DECISION DELEGATED TO HEAD OF PLANNING

Application No: H07-0329-26 **Applicant:** Mr N Hadingham
Proposal: Change of Use of Agricultural Building into Dwelling
Location: The Limes 56 Station Road Gedney Hill
Terminal Date: 10th June 2026

TITLE
PROPOSED BUILDING
PLAN & ELEVATIONS

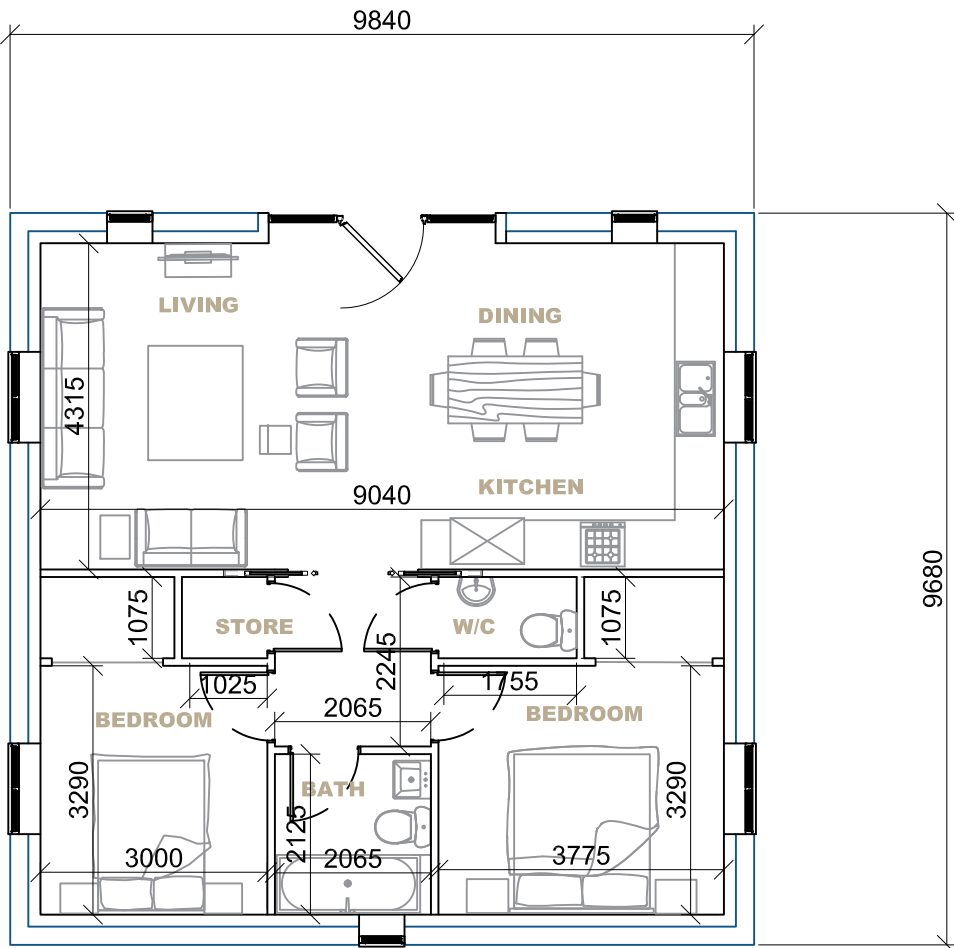
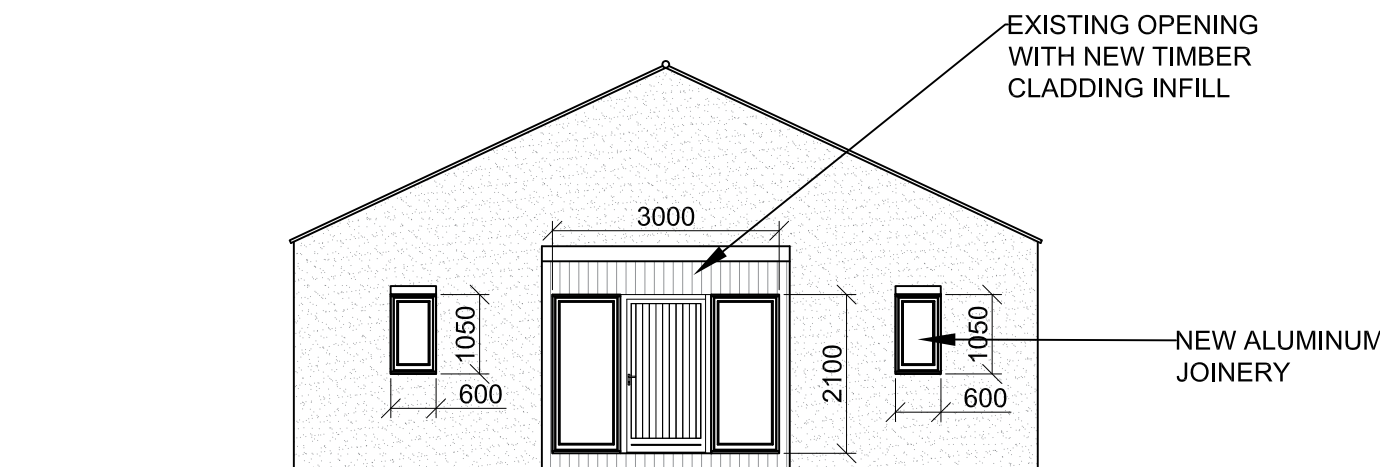
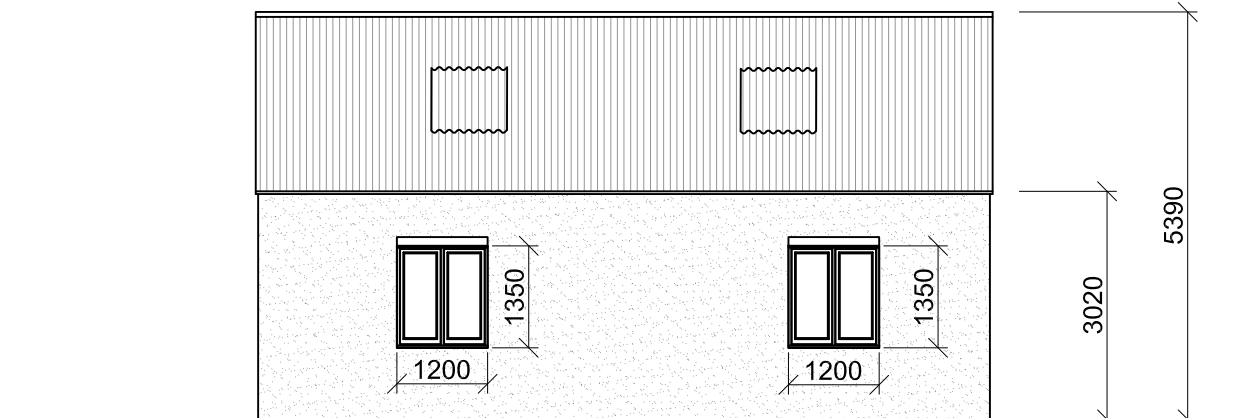
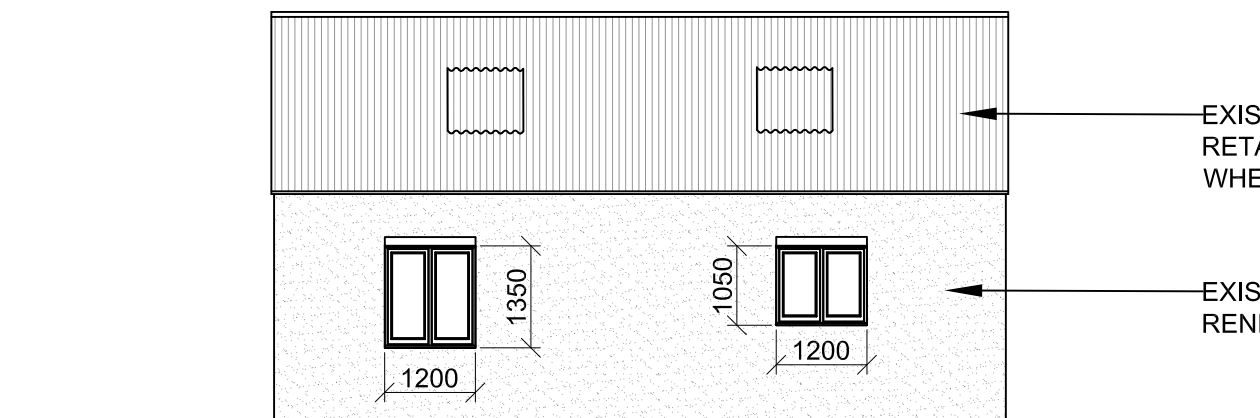
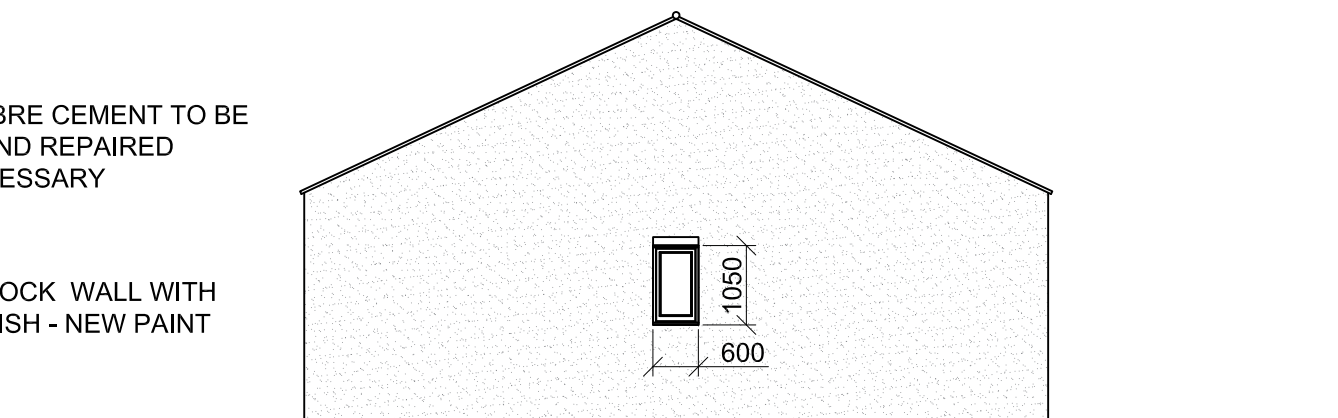
The dwellings itself, and all bedrooms shown, conform to the requirements of the National Space Standards with respect to floor area.

No exact details of floor to ceiling height have been provided. However, the plans show an eaves height of 3.02m and a ridge 5.39m. Seeing as floor levels would not be raised, the floor to ceiling heights proposed are acceptable.

The alterations to the building are minimal. The resultant dwelling, whilst not of significant merit, would represent an enhancement, via the replacement of existing rendering etc, over the existing building.

(g) The provision of adequate natural light in all habitable rooms - Each habitable room has at least one window to ensure that adequate natural light be provided alongside suitable ventilation given the location of windows on the building.

BLOCK PLAN
Scale 1:500

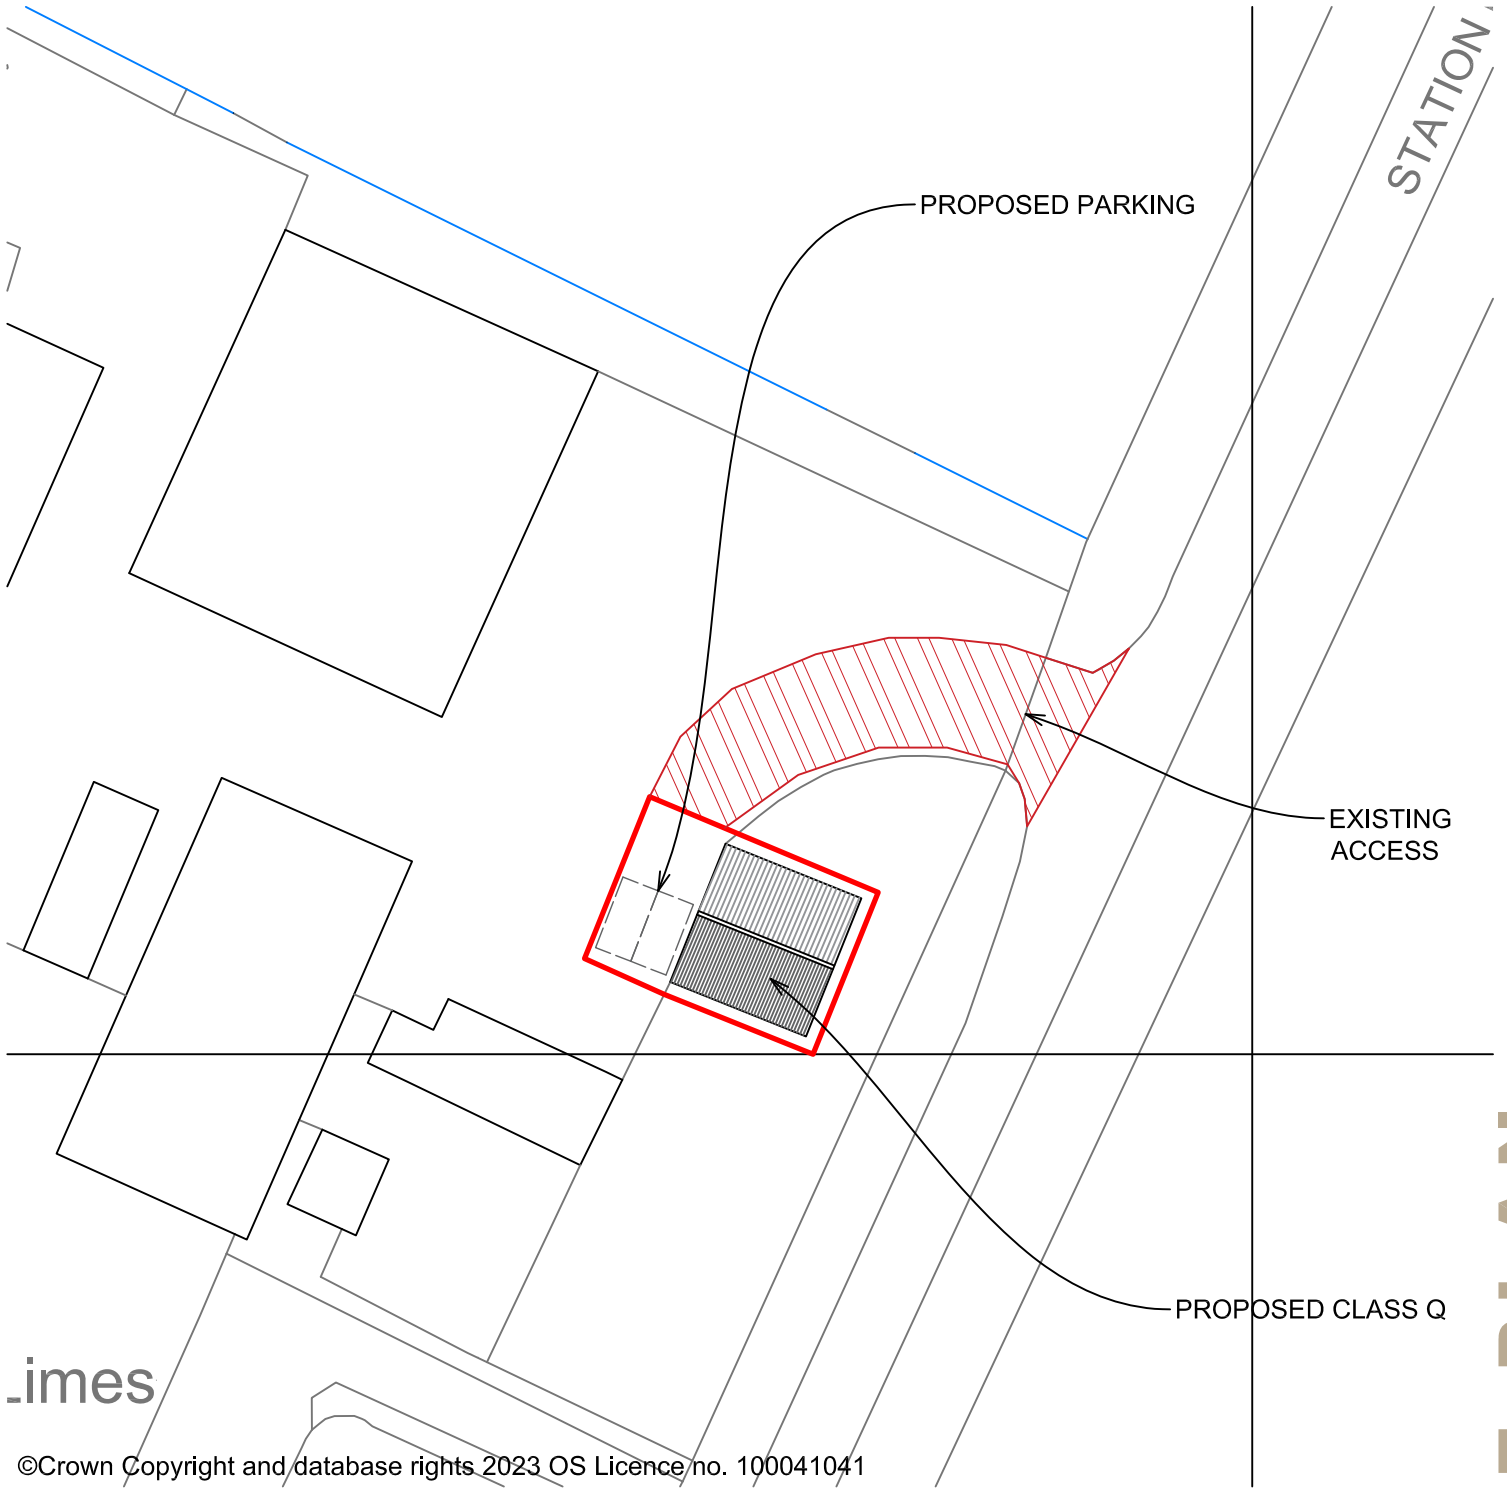
Suitable access to the site has been provided, via a shared access with the nearby agricultural yard.
